# KITTITAS COUNTY FIRE MARSHAL'S OFFICE

November 30, 2016

Re: Highway 9 Office Park (BL-16-00016)

PRELIMINARY BOUNDARY LINE ADJUSTMENT

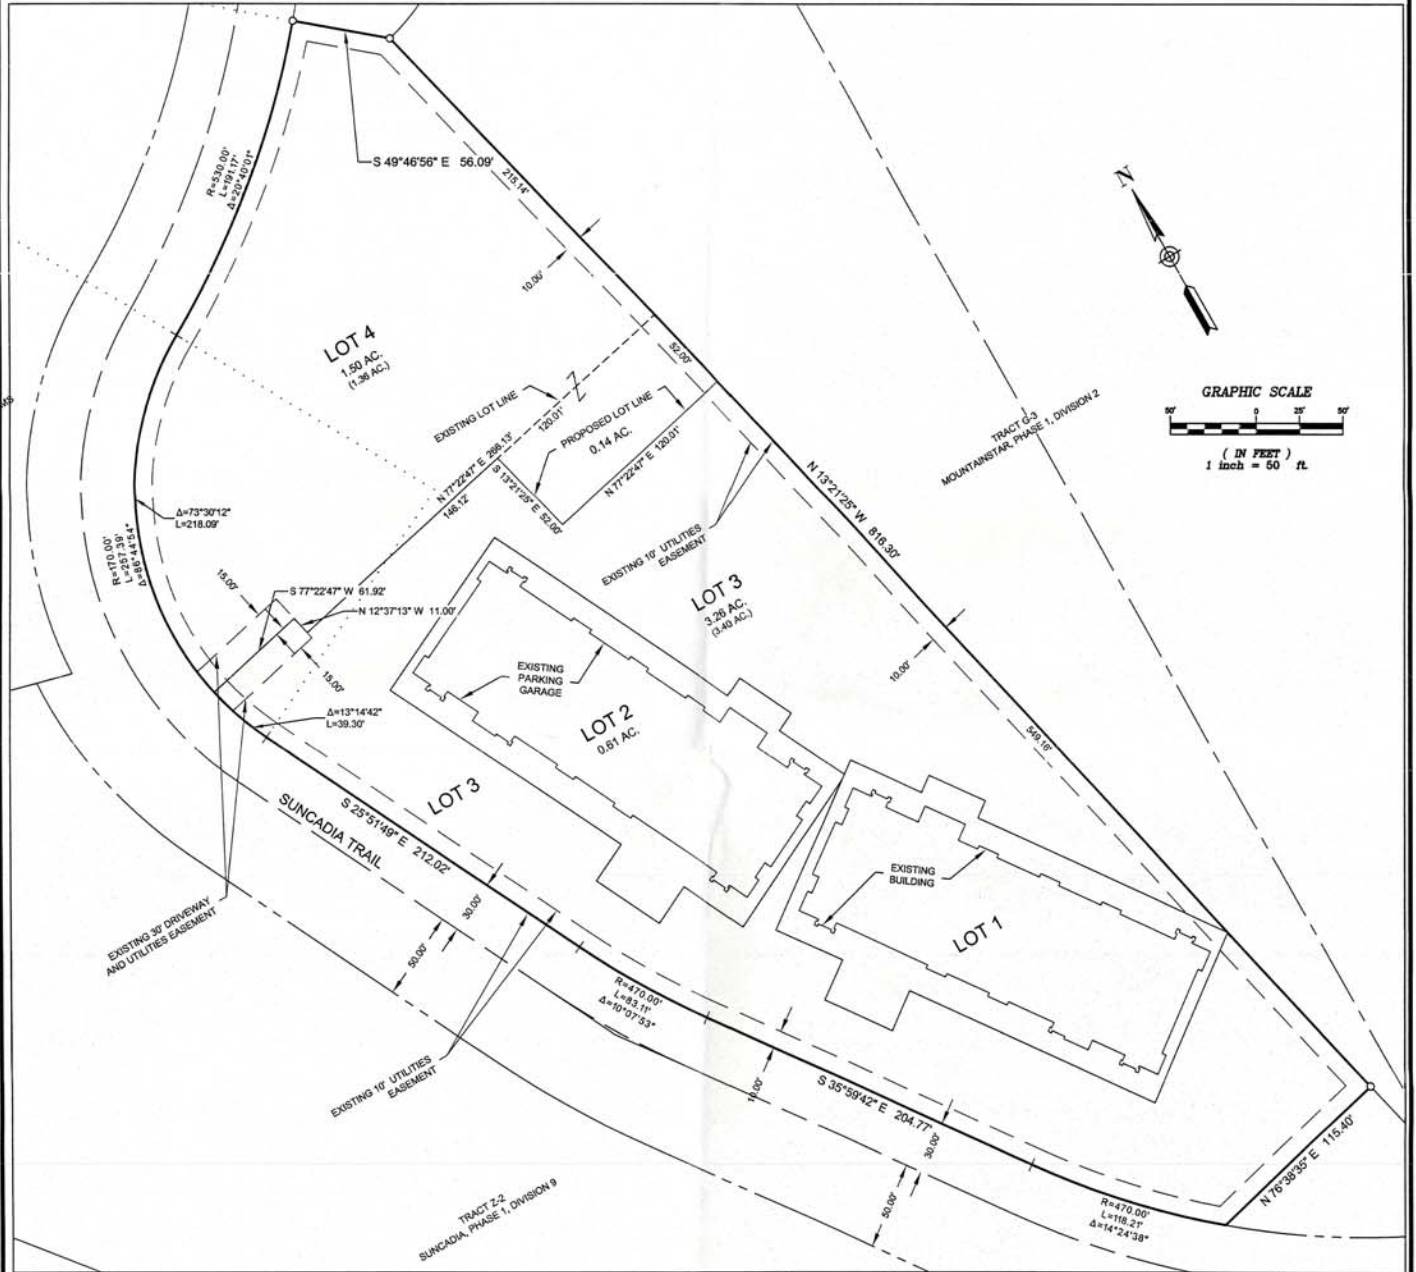
- Ensure that boundary line adjustments do not infringe upon existing structures.
- Ensure adequate access for fire apparatus. Any driveways or access points created based off the new lot configurations shall comply with Kittitas County Code 20.02.030.
- All future development must comply with the International Fire Code.
